November 9, 2020

El Paso County
Engineering Department
Attn: Jeff Rice

**RE: Windermere – 2nd Review Comments Response Letter
SP-19-003**

Please accept this response letter to your review comments dated August 17, 2020 for the above application.

**PRELIMINARY GRADING PLAN**

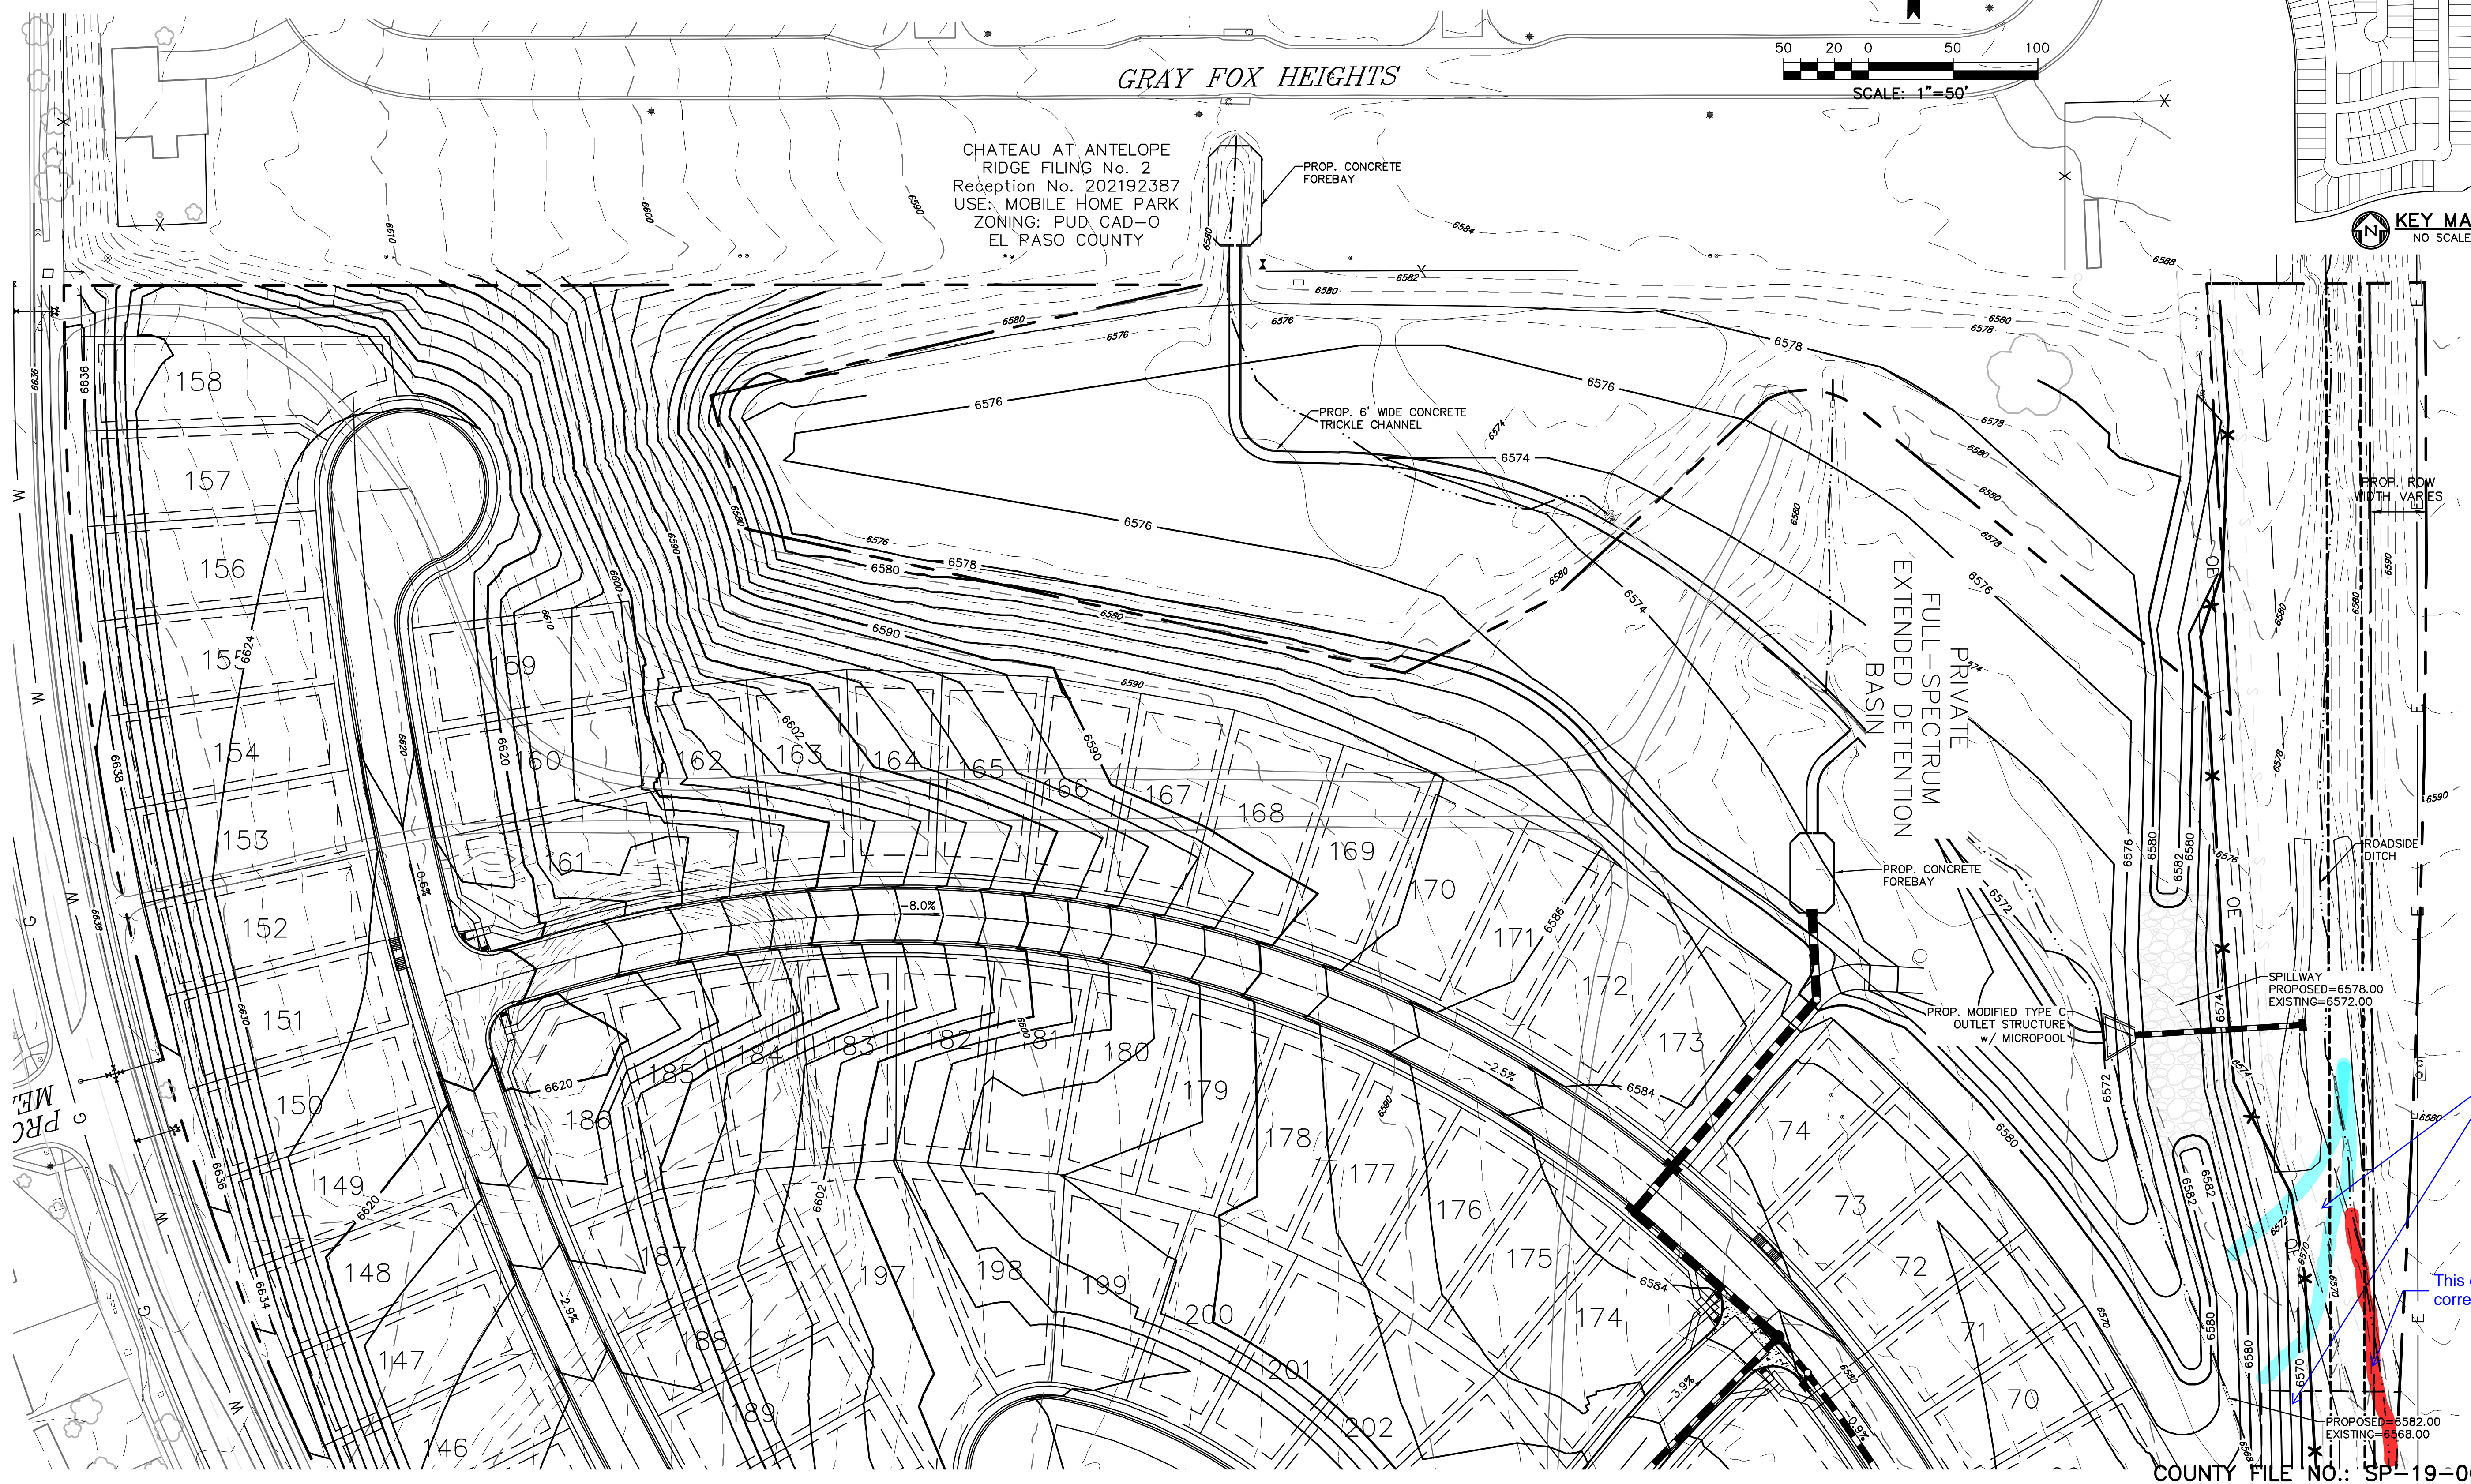
- b. **Complete design details and grading and erosion control are required for the improvements at the southeast corner. It is unlikely that the existing area inlet will be allowed to be moved out of the existing County easement, or grading (fill) within the easement allowed. *The existing inlet location will not be moved. A variance for grading in the easement will be applied for.***

- c. **See redlines regarding grading in the County easement near the northeast corner of the property (same issue as 3.b, above). *A variance for grading in the easement will be applied for.***
